From: Sue Howell <Sue.Howell@arun.gov.uk>
Sent: 23 September 2021 16:06
To: Michael Eastham <Michael.Eastham@arun.gov.uk>
Subject: FW: Planning Consultation on: WA/63/21/PL

Application ref: WA/63/21/PL

Description: Proposed alternative vehicular accesses off Tye Lane and emergency access off Avisford Park Road, along with minor highway works following WA/95/18/RES (resubmission following WA/93/20/PL). This site is CIL Zone 2 (Zero Rated) as other development.

Location: Land East of Tye Lane Walberton BN18 0LU

VIEWPORT 1 - PROPOSED RESIDENTIAL ACCESS AT TYE LANE

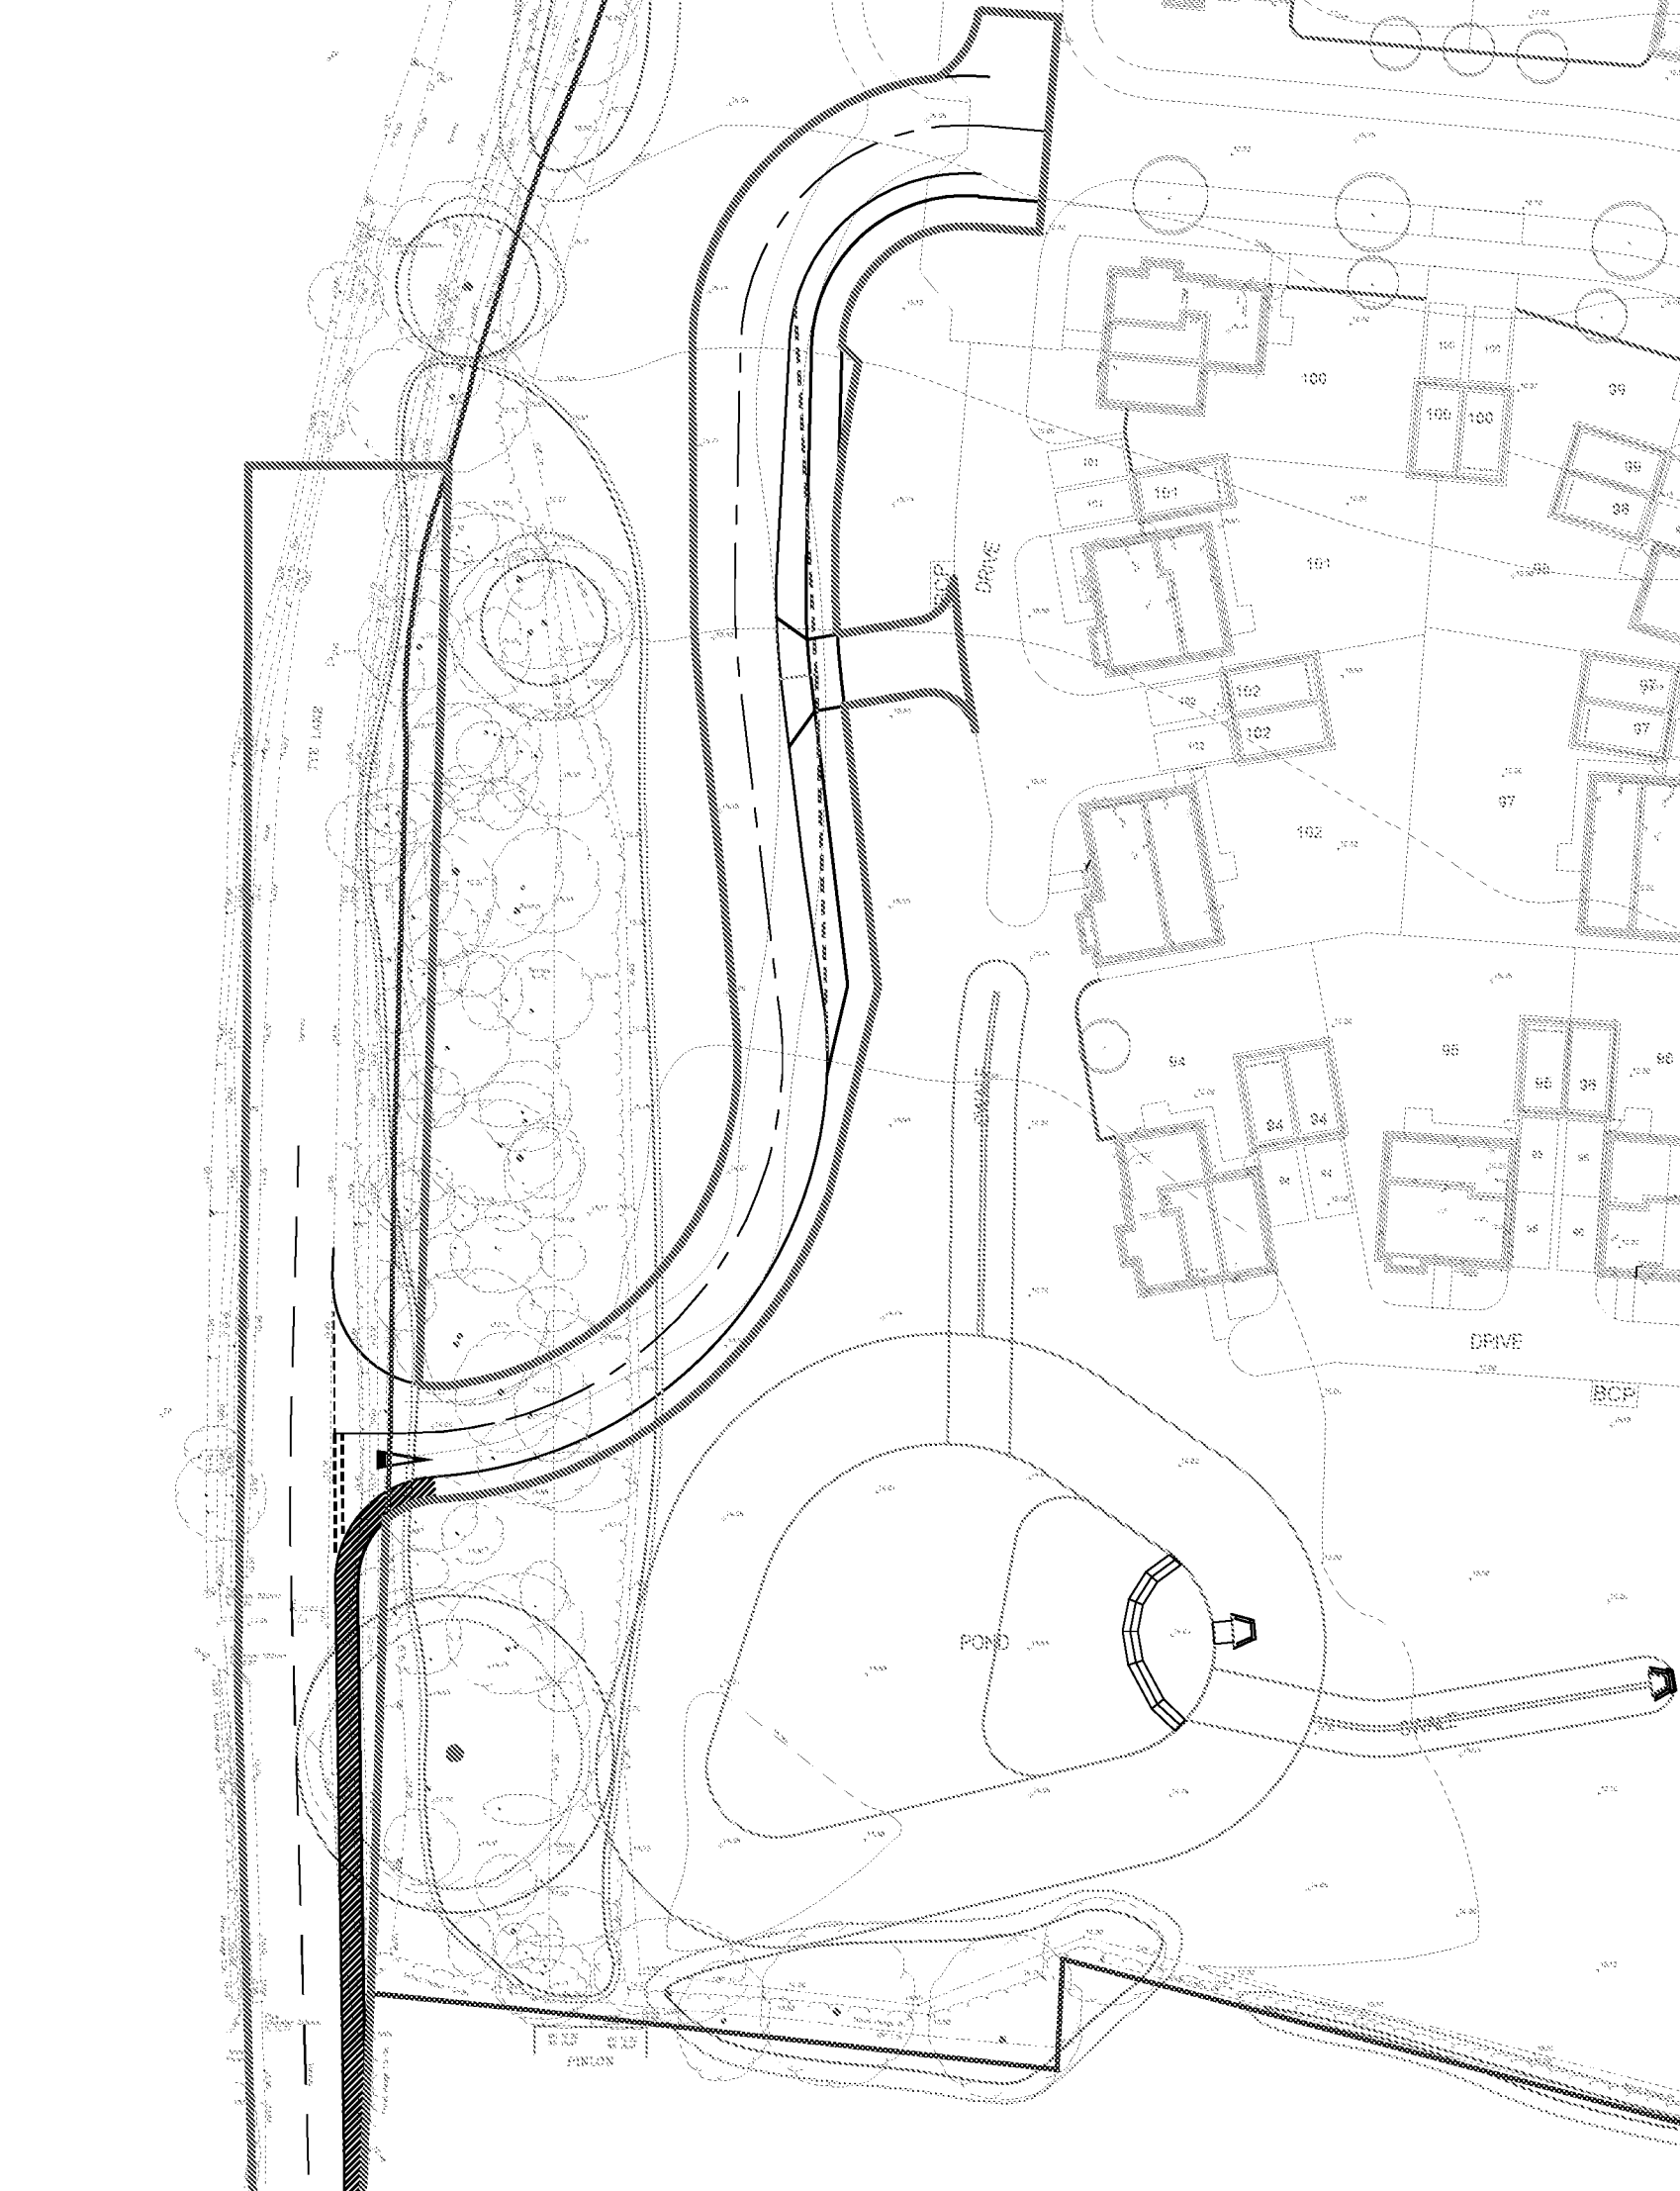
Public Open Space Landscape Proposals Sheet 1 of 4 CSA/3823/107 /Rev Q has proposed alternative vehicular accesses off Tye Lane where an area of existing hedgerow and trees within this site boundary will be effected by the proposals. The actual detail of the proposed removals is still not clear, particularly re proposed tree removals, this information will be required to be submitted for approval by the LPA Tree Officer. Landscape mitigation and replanting to this proposed entrance will need to be submitted for approval.

VIEWPORT 2 - PROPOSED EMERGENCY ACCESS AT AVISFOD PARK ROAD

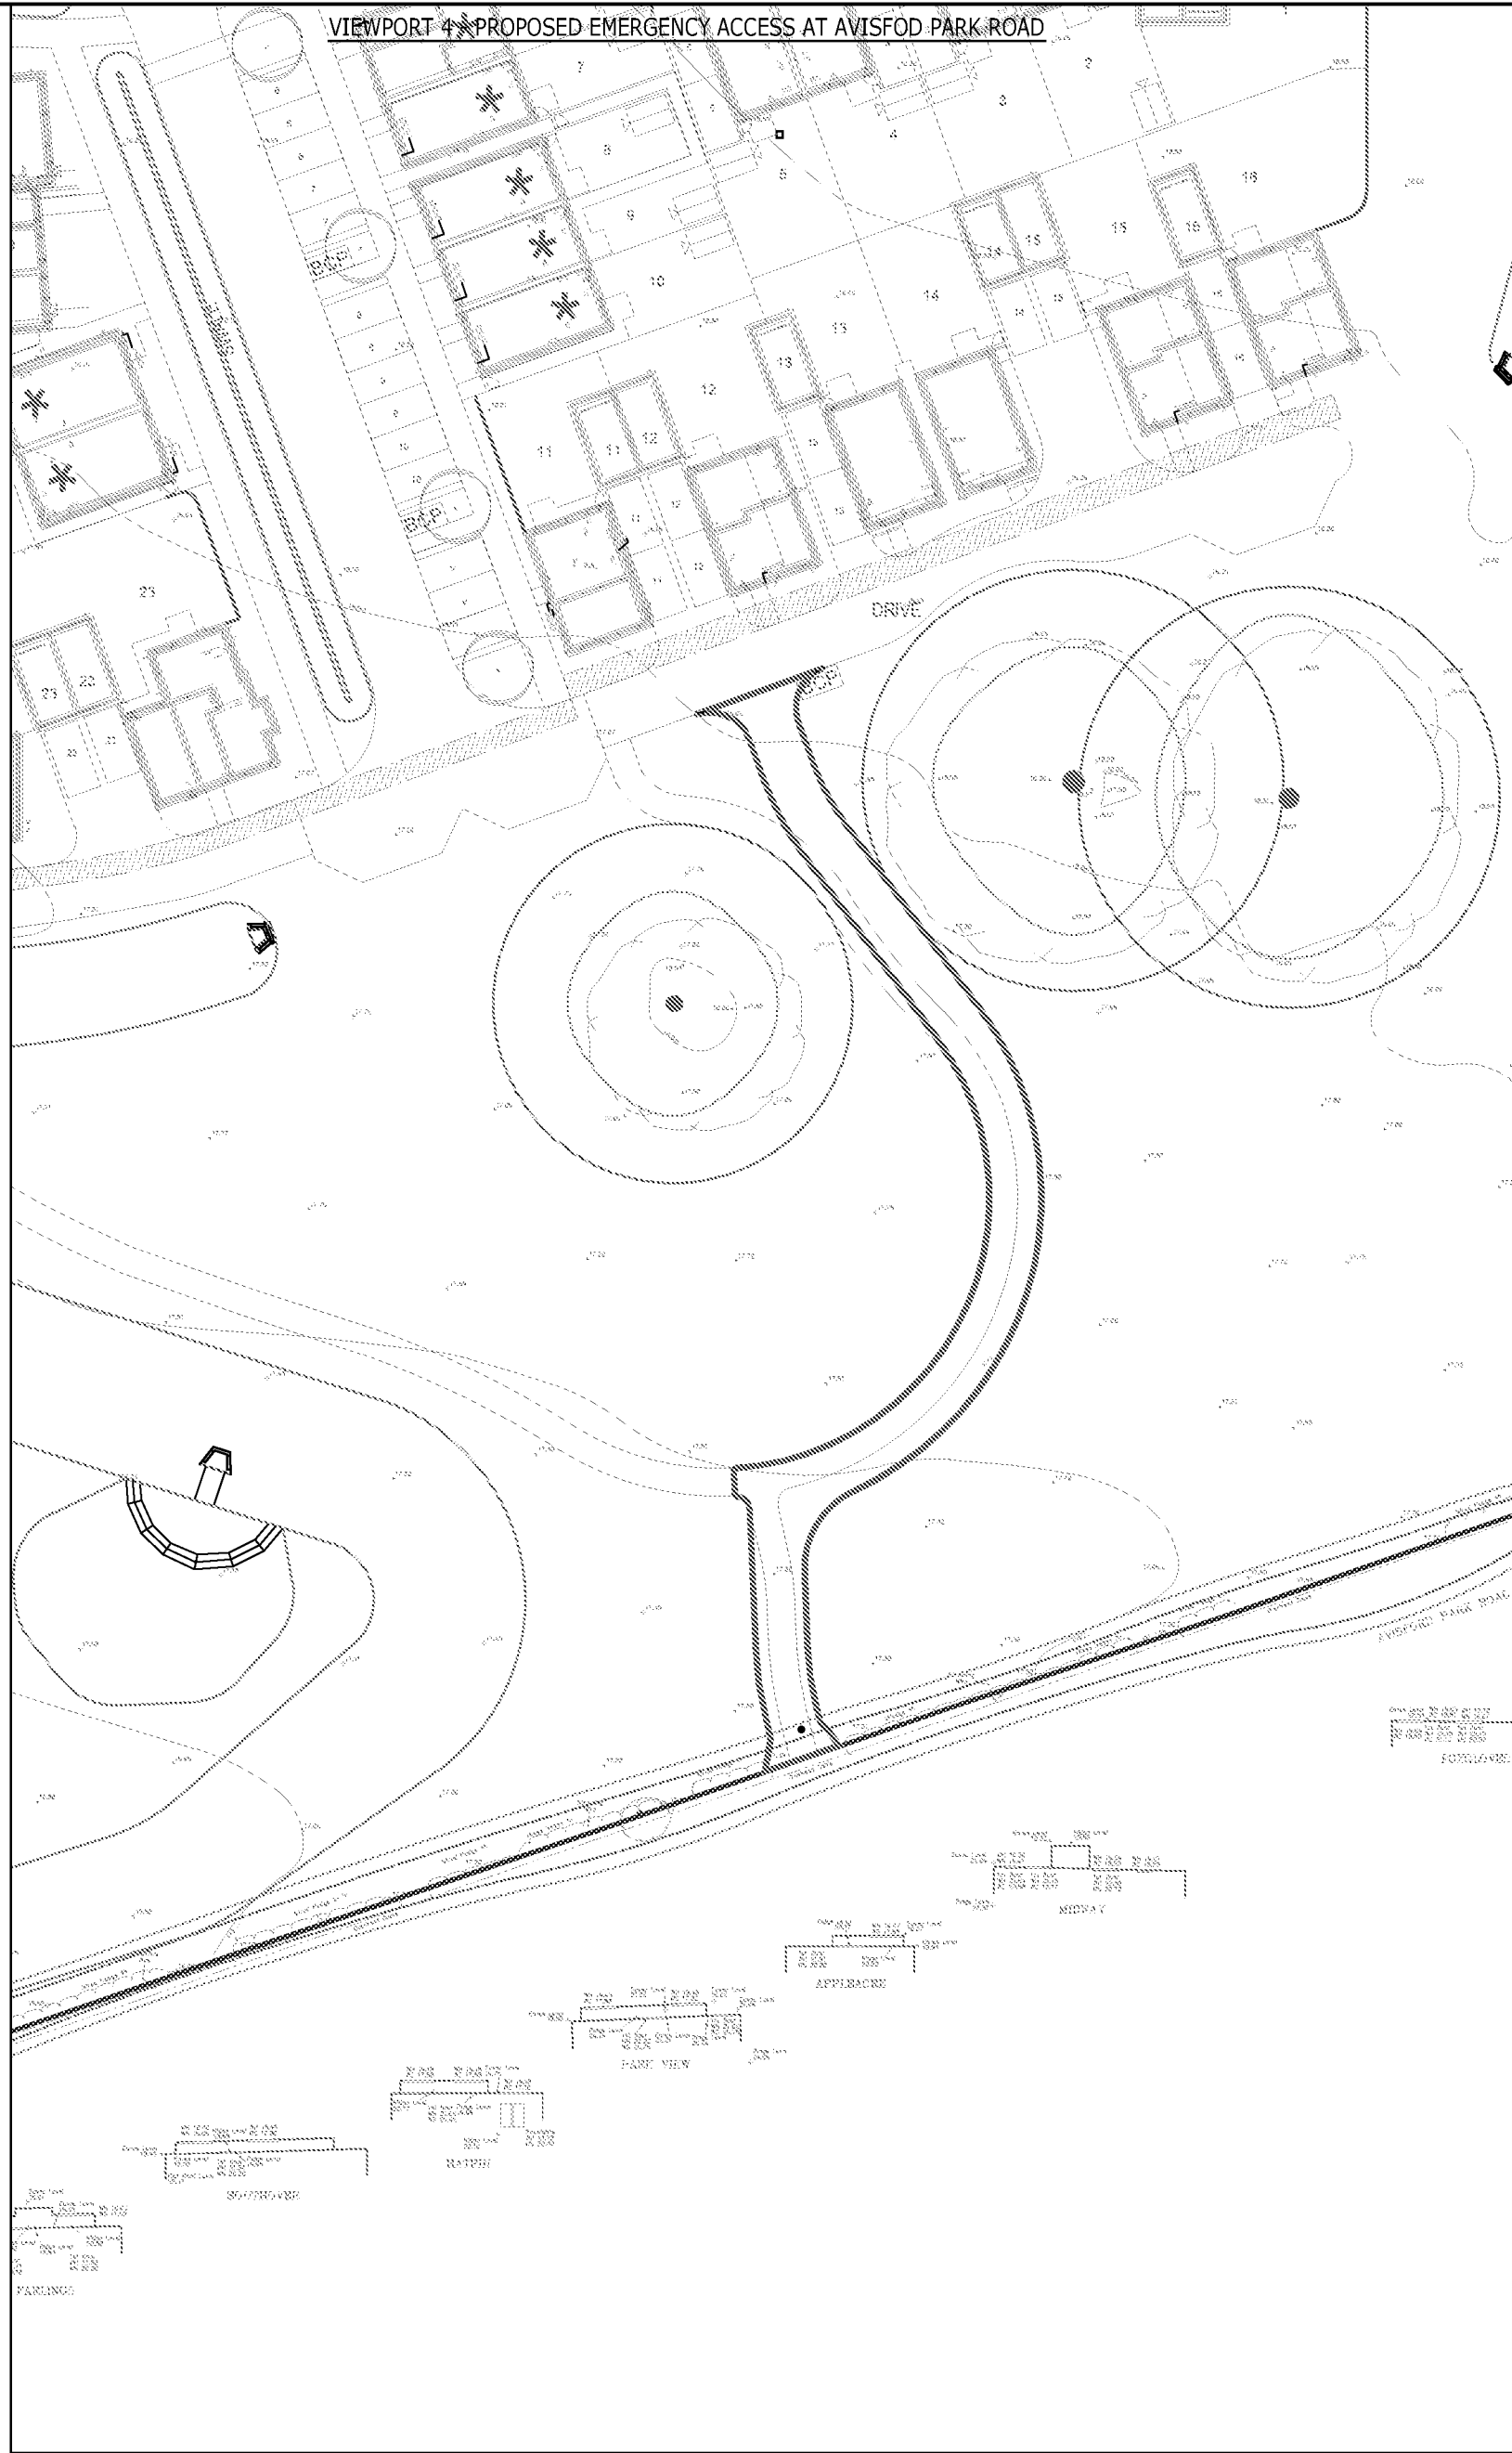
Public Open Space Landscape Proposals Sheet 3 of 4 CSA/3823/109/Rev P details the emergency access off Avisford Park Road. This connection into and through the site is not ideal with routing through a key area of POS, the community orchard and passing adjacent to the LAP. Recommendation would be that this road is subject to restricted access for emergency access only and should not be considered for any other access purposes. In addition it should be imposed that knee rail fencing is now included along the LAP edge which borders this roadway.

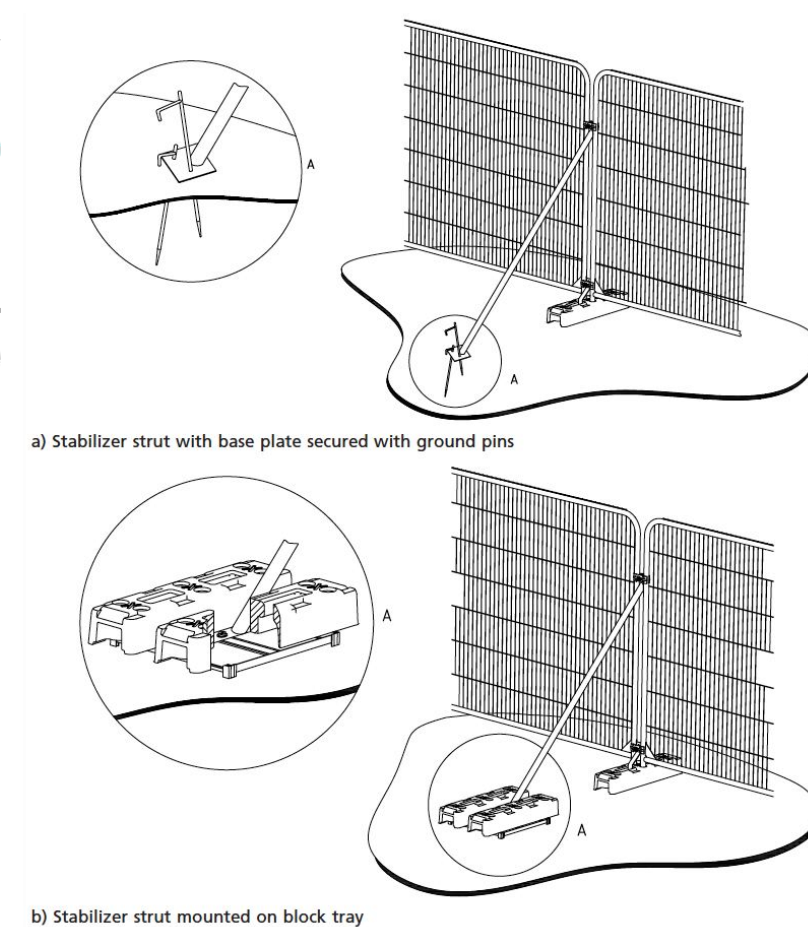
Whilst the Landscape drawing POS Landscape proposals Sheet 1 of 4 CSA/38 23/107 Rev Q doesn't show the existing and to remain green infrastructure it does show the proposed landscape mitigation including native thicket and tree planting which when read in conjunction with Combined Tree Retention/Removal and Protection plan access arrangements BHA 401-03-REV A the proposals for the impact and mitigation for this new entrance would appear sufficient and appropriate.

Additional landscape provision will be required once the extent of the required removals is known. Additional protection will be required to the adjacent trees and hedges which are to remain in this area and whose canopy and root protection areas will fall within the construction area of these proposals. The green boundary treatment and mitigation to counteract the proposed loss along this entrance boundary will need
